DESIGNER'S RESPONSE

Road Safety Audit Stage 1

Crossley Lane, Dalton, Kirklees - Road Safety Audit Stage 1

2021-10 Dalton RSA1 – Revision 0

Landscaping

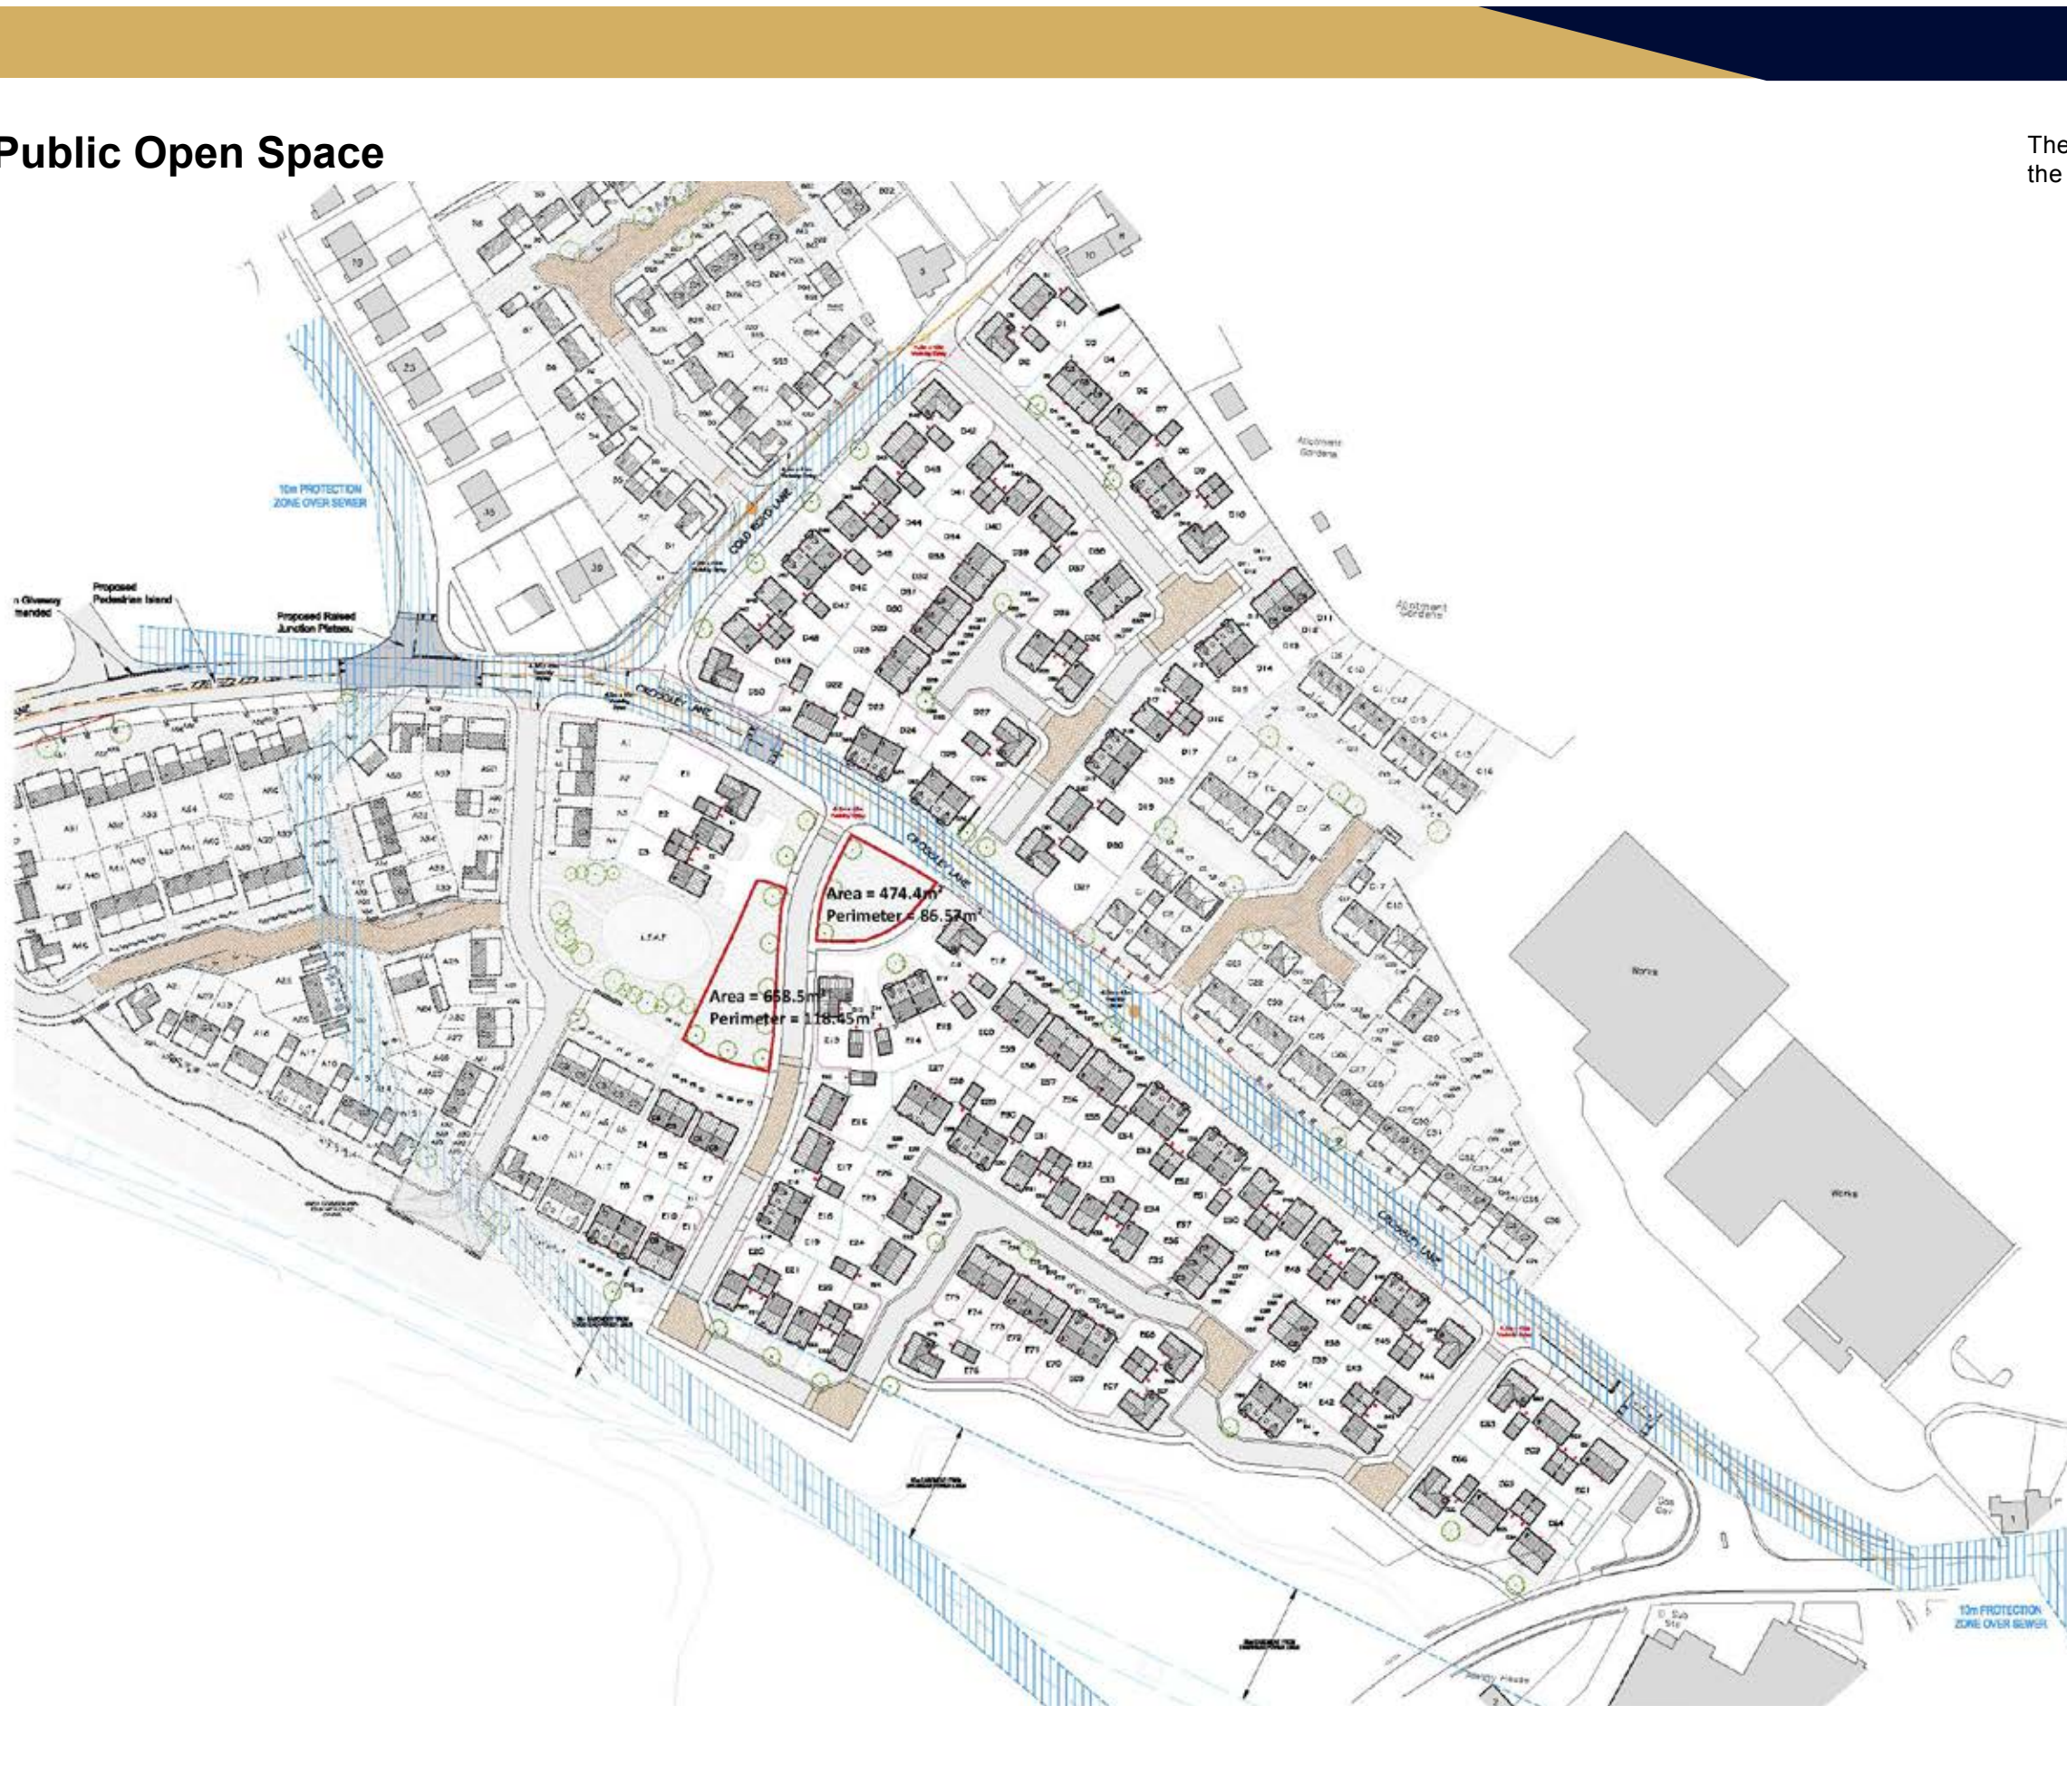
No details have been provided of the type and height of the planting to be provided as part of the landscaping proposals. There appears to be a number of locations, in particular near junctions where a circular element indicates a shrub, bush or tree. These soft landscaping features could impact upon junction visibility if the chosen plants grow to a height that could screen junction visibility, increasing the risk of junction related collisions and also screen pedestrians, especially younger children, who may be crossing or playing in these residential streets, increasing the risk of vehicle to pedestrian collisions.

It is recommended that the proposed landscaping accommodates the required visibility standards as outlined in Manual for Streets. i.e. when mature should not exceed 600mm from the adjoining carriageway surface or the underside of any tree canopy to be above 2000mm.

Accepted – landscaping within visibility splays shall not exceed 600mm in height as recommended.
